Comments for Planning Application 20/00971/FUL

Application Number: 20/00971/FUL

Address: 21 Elliott Rise Ascot Berkshire SL5 8NN

Proposal: Erection of two storey side extension, single storey rear extension and front porch.

Proposed Ground Floor Plan  
1:50

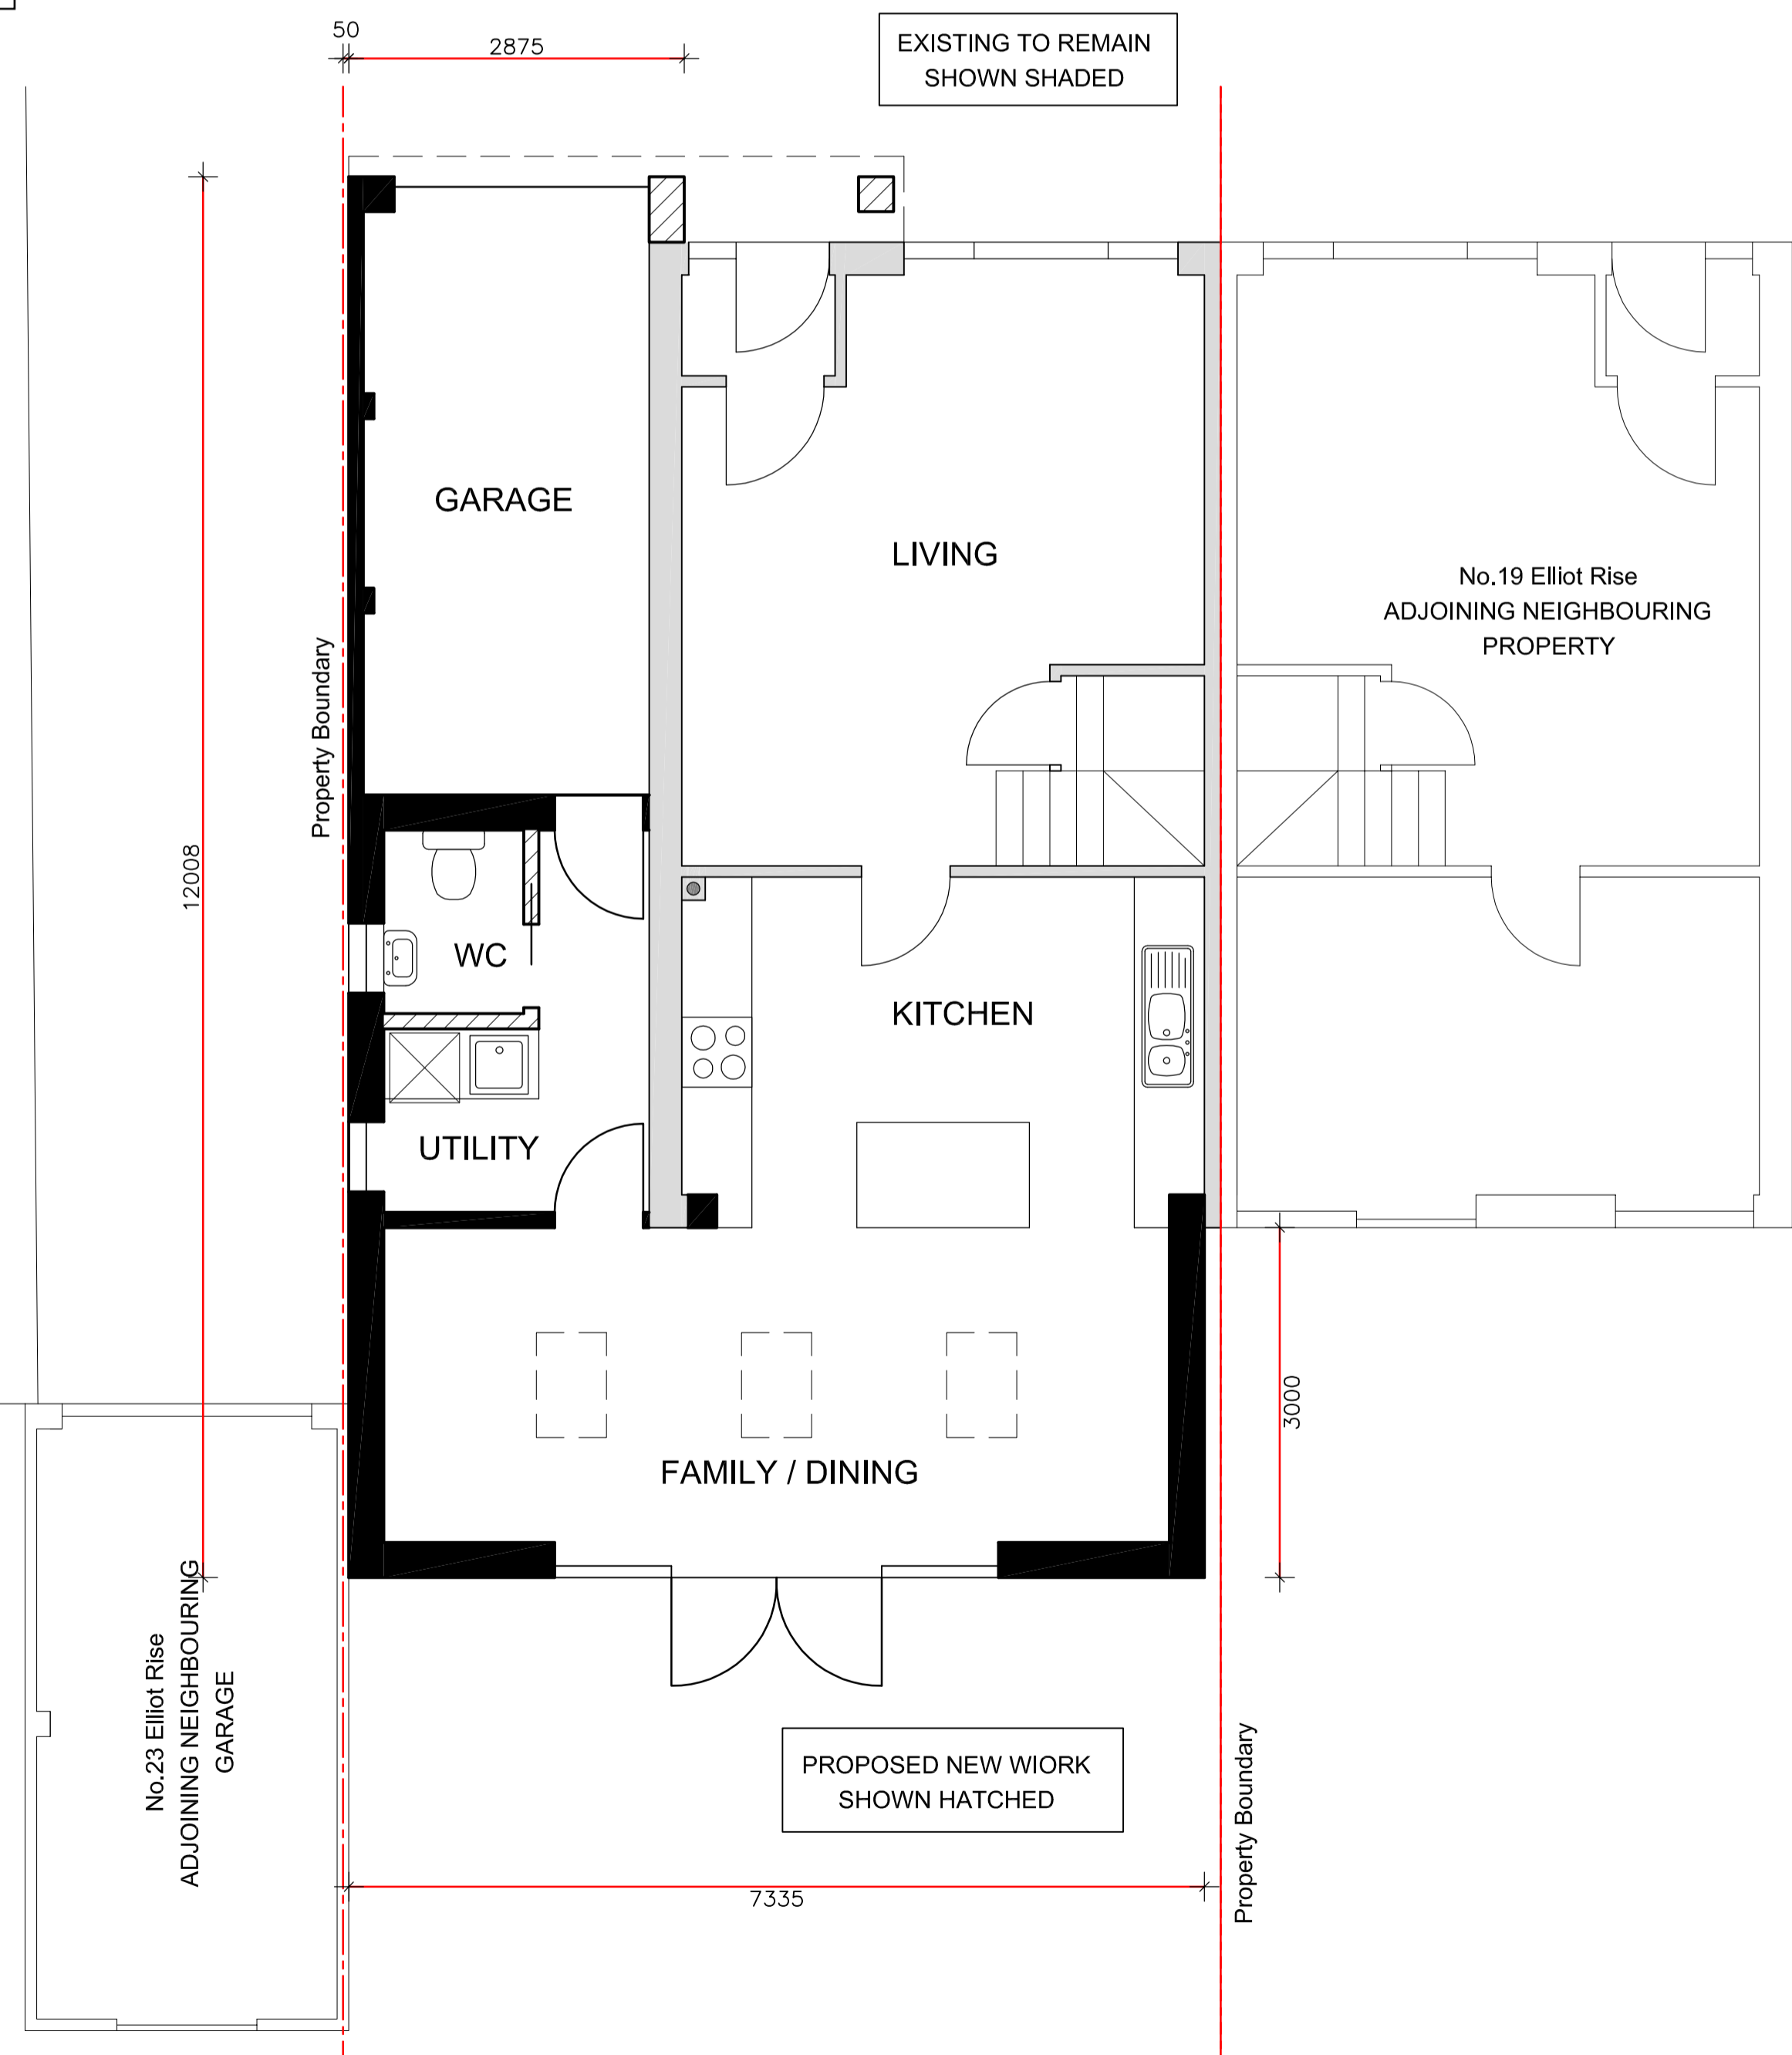
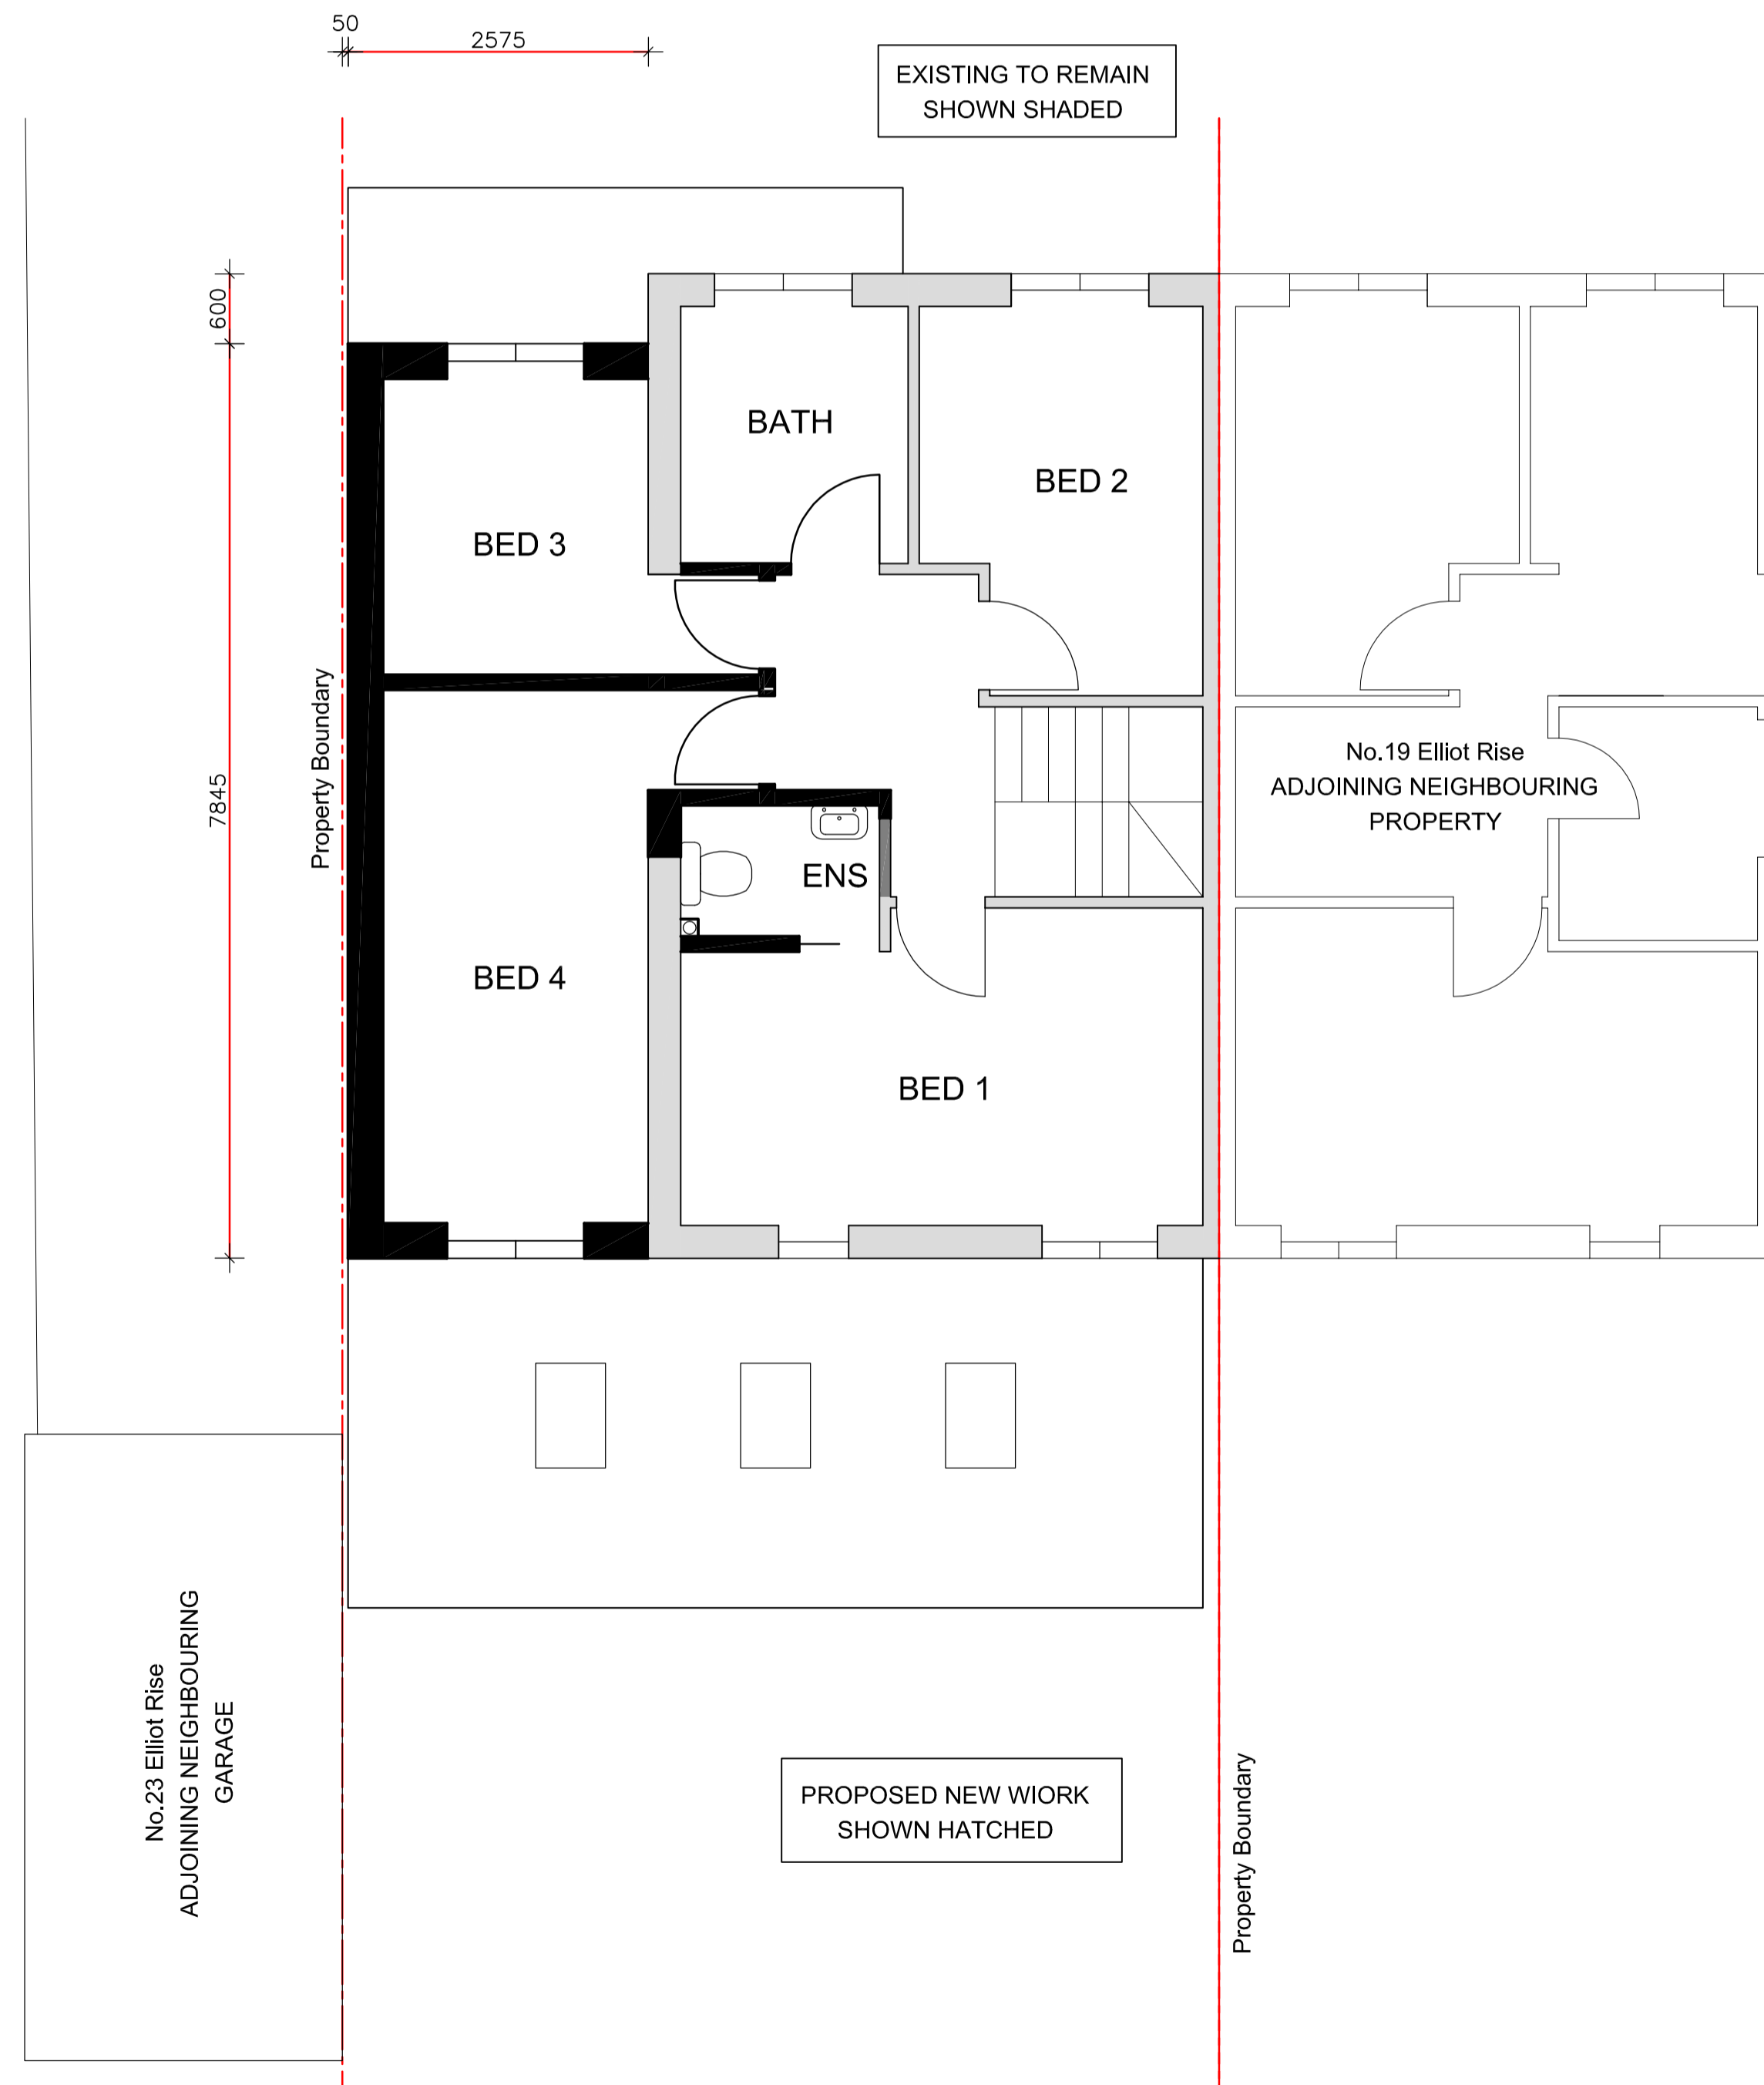
We share the drive with the proposed property. While we support this planning application, we would request that the proposed utility window is removed as it will open into our garden. Because we plan to remove our back fence as the fence will be redundant.

We also note that only one parking space in the garage is provided, the extension might need more than one parking which might need the curb to be dropped.
